CITY OF ALBUQUERQUE

**RE: Main Event, Albuquerque Carpenters Training Center (File: G16-D149)
4040 Pan American Freeway NE 87107
Grading Plan and Drainage Plan, Engineer's Stamp Date 5-27-2015
Engineer's Certification Dated 5-27-16 and 6-6-16**

**RE: Main Event, Albuquerque Carpenters Training Center (File: G16-D149)
4040 Pan American Freeway NE 87107
Interim Grading Plan and Drainage Plan, Engineer's Stamp Date 5-27-2015**

MAIN EVENT
PAN AM FREEWAY AND VASSAR AV.
INTERIM DRAINAGE PLAN - LOT 2B

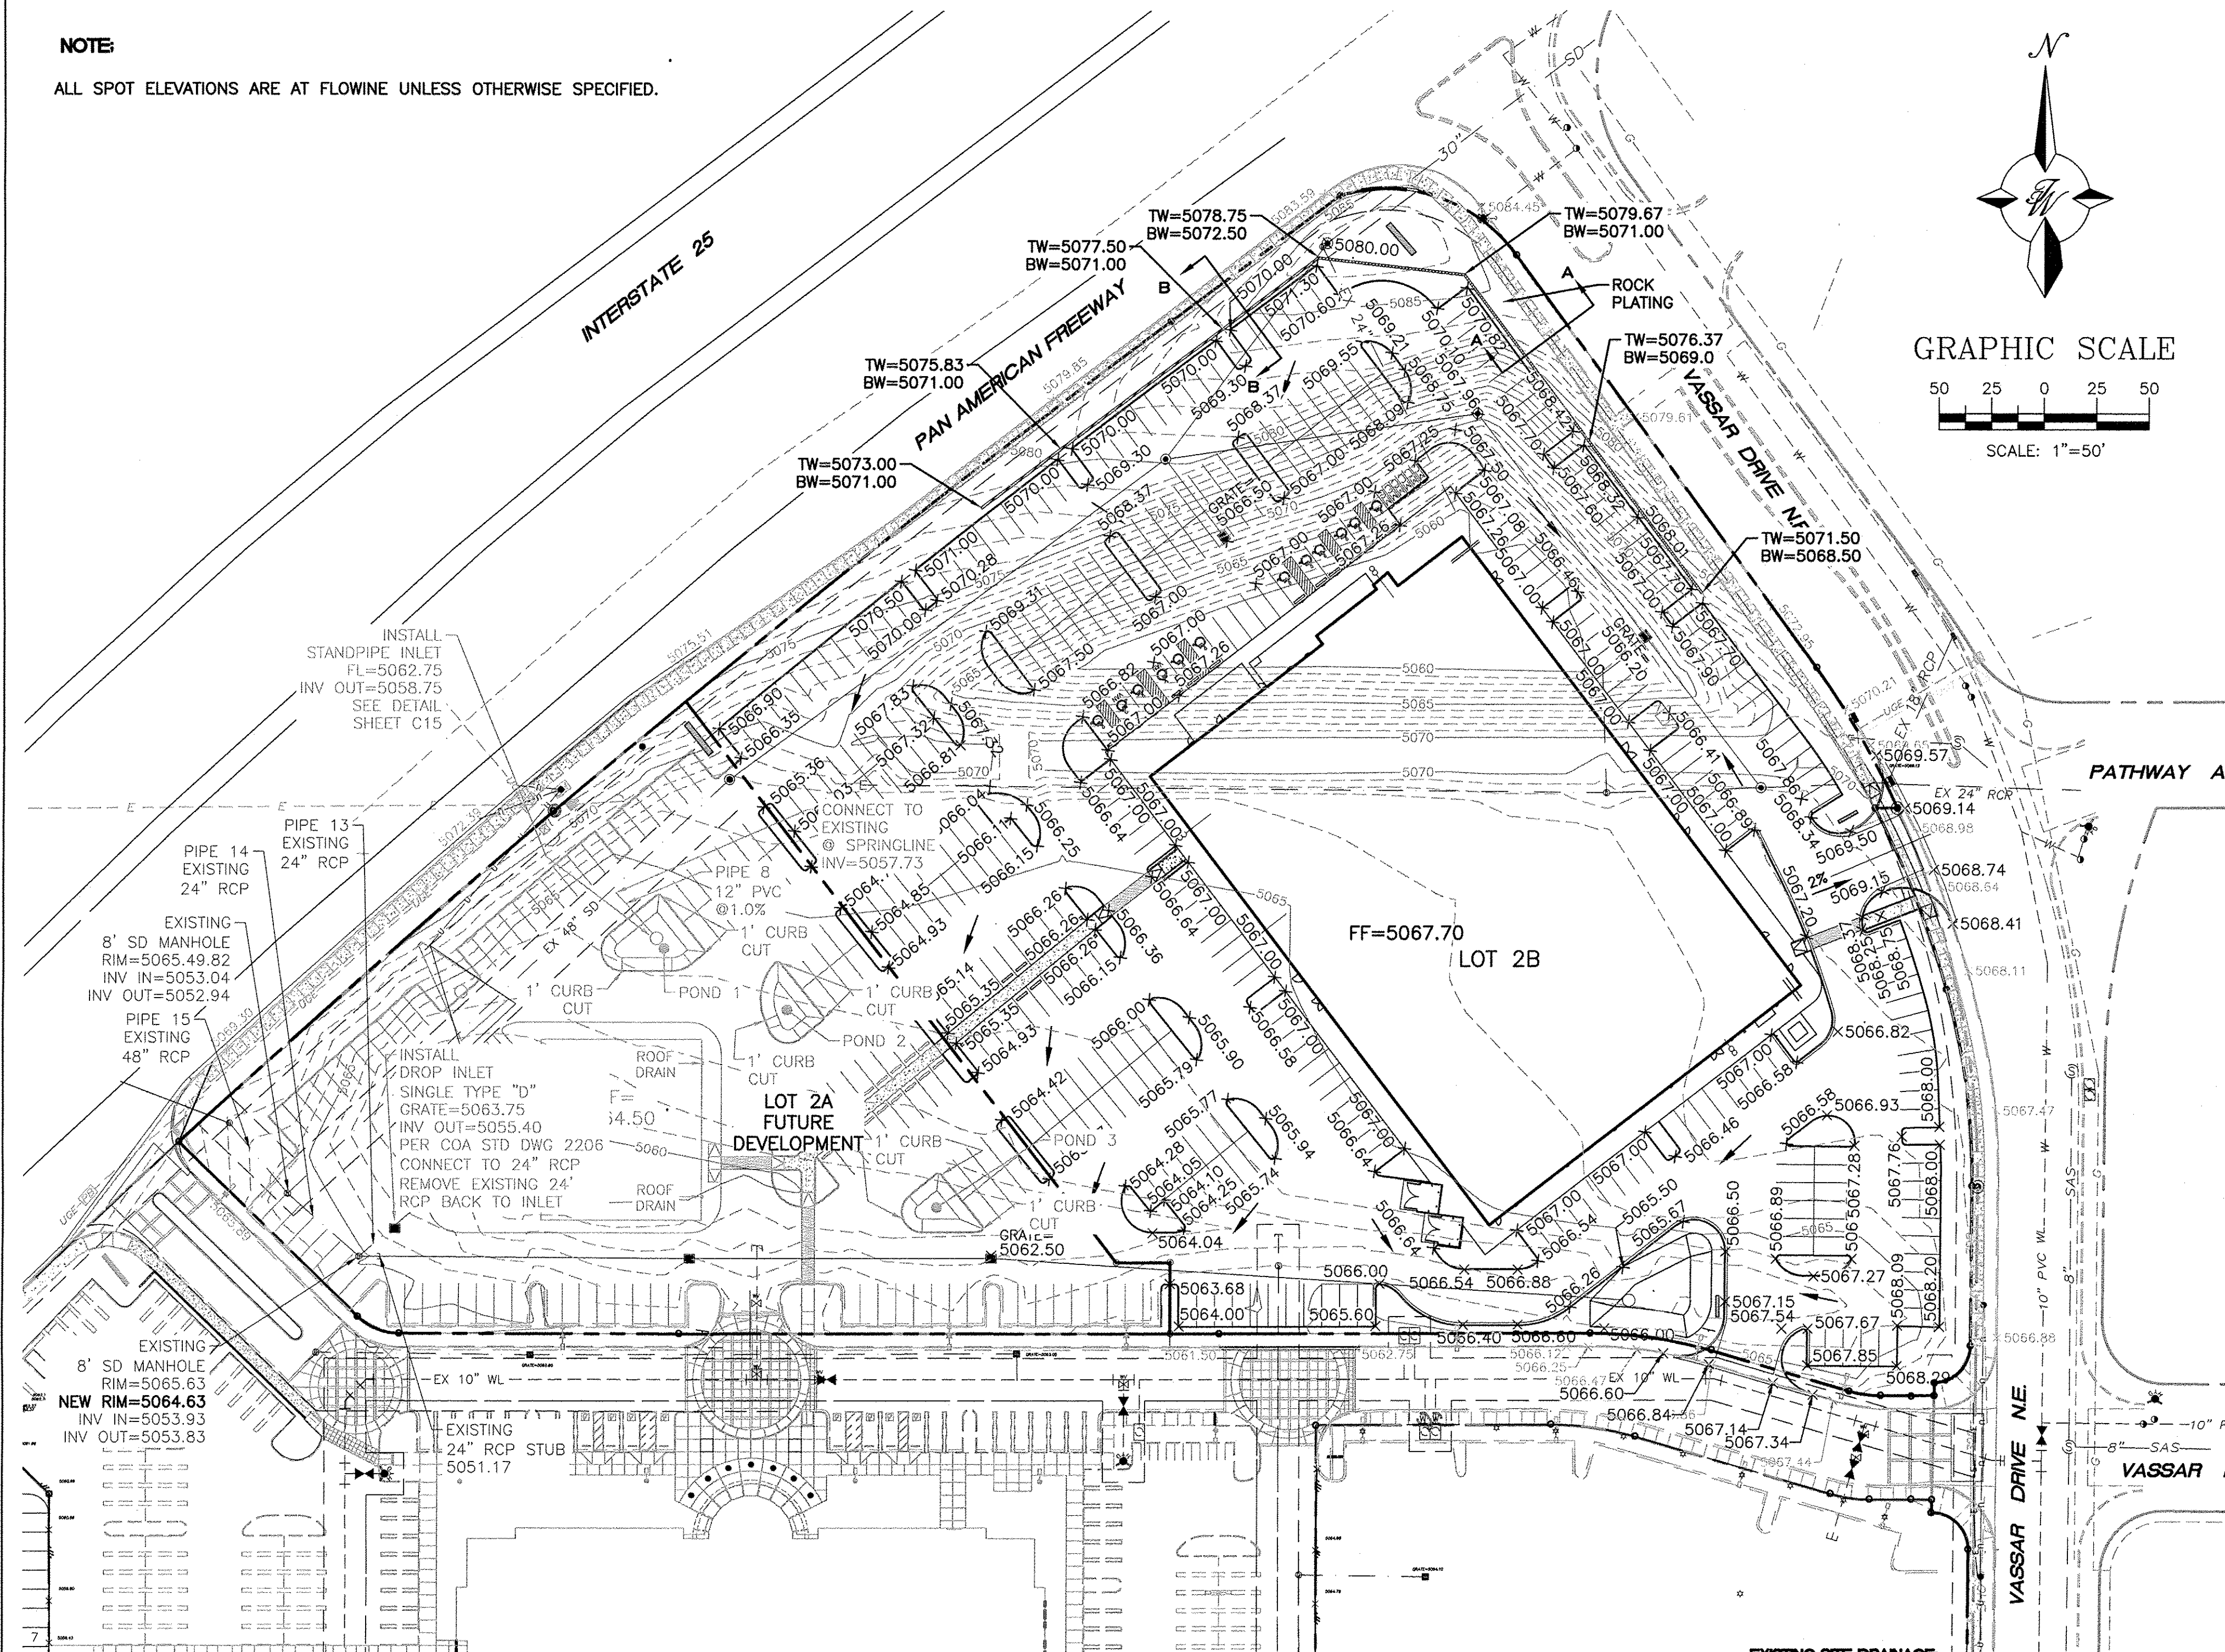
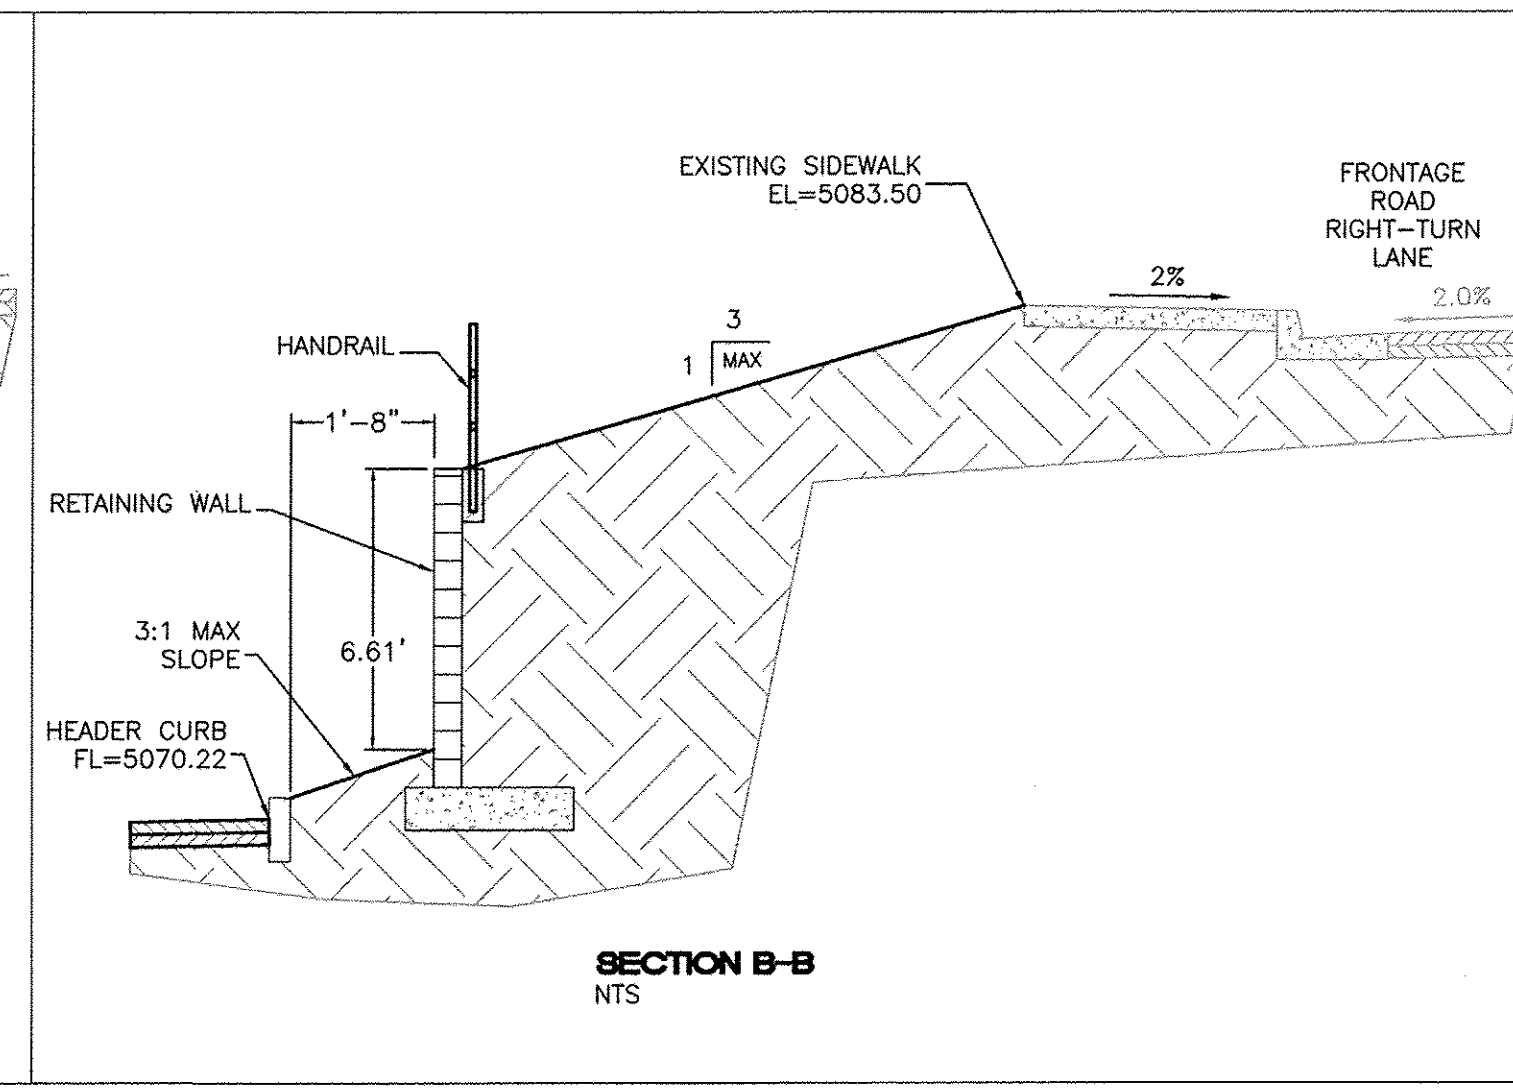
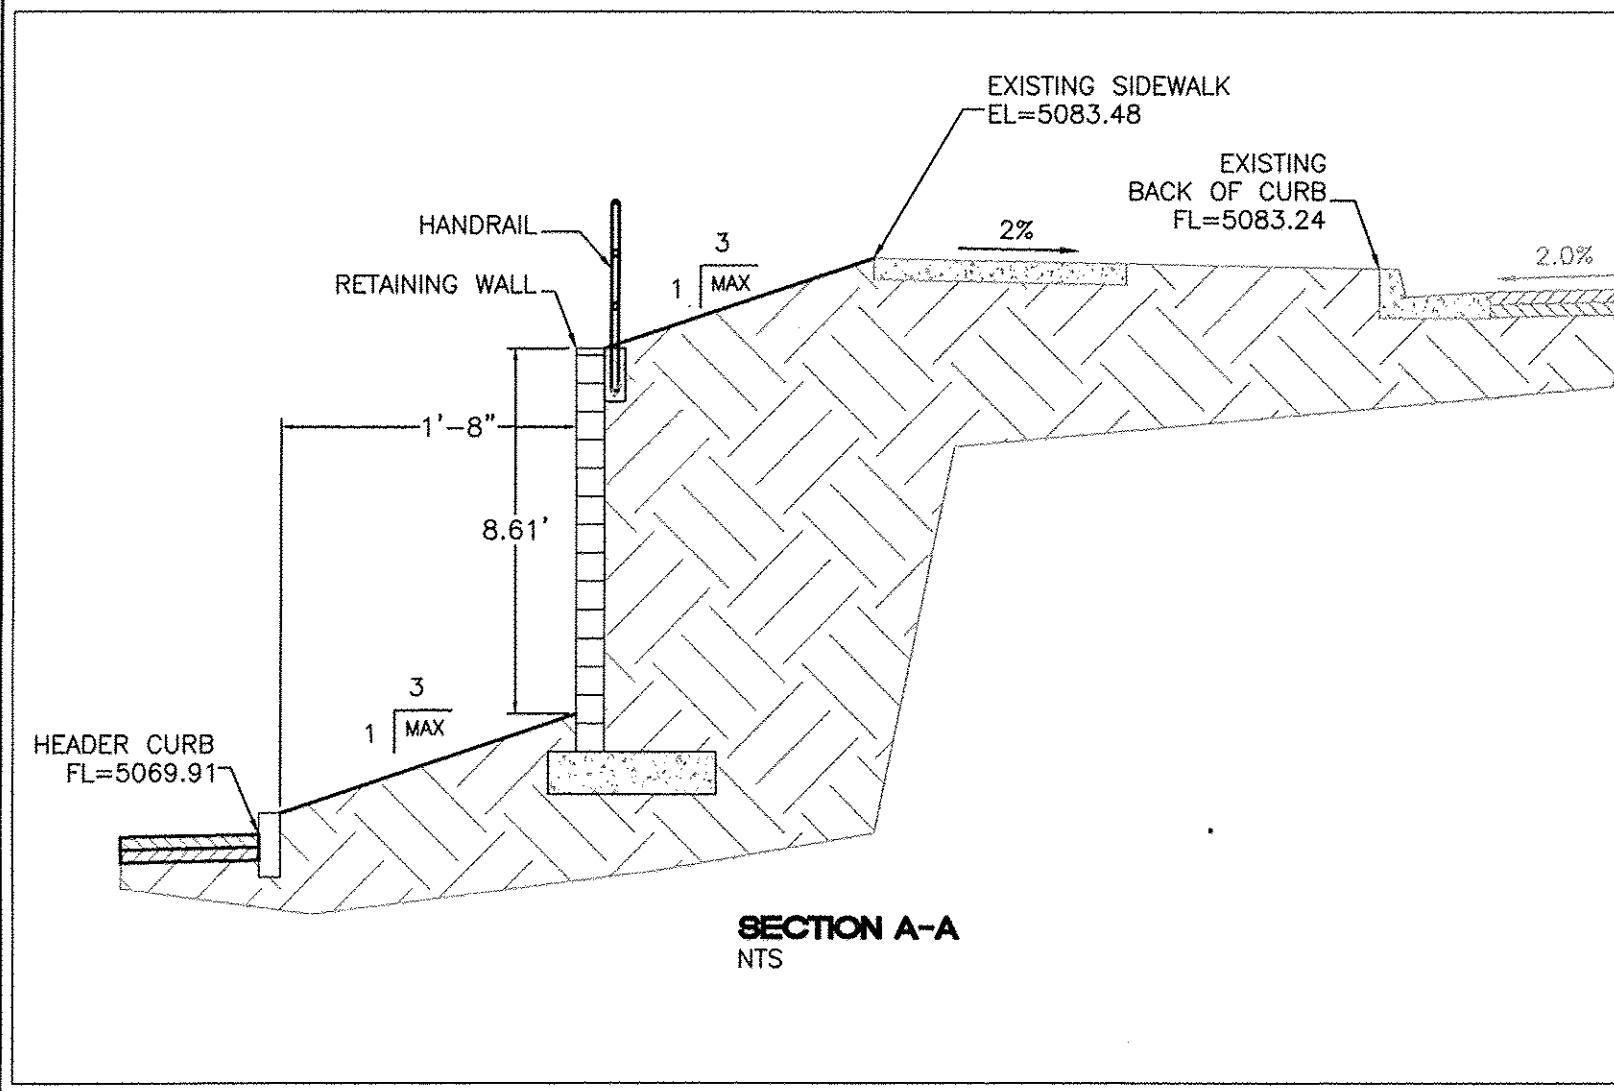
An Interim Grading Plan was submitted, but it does not show how the drainage was to work in the interim – so I don't understand it's purpose. The only difference I can see is that the future work was greyed out. My comment letter for the Temp C.O. did not require an interim grading plan at this point, since it is rather late in the game, but did ask that one be provided for future projects if the project was to be phased.

I do not believe the Interim grading Plan is necessary at this point, so I will not approve it. However, I do need the Eng. Cert to be amended as stated above (and keeping the " future" improvements as greyed out as has been shown).

While this interim plan did not show how the interim drainage was to function, this is the plan used for the Engineer's Certification. For this reason, this interim plan is being approved.
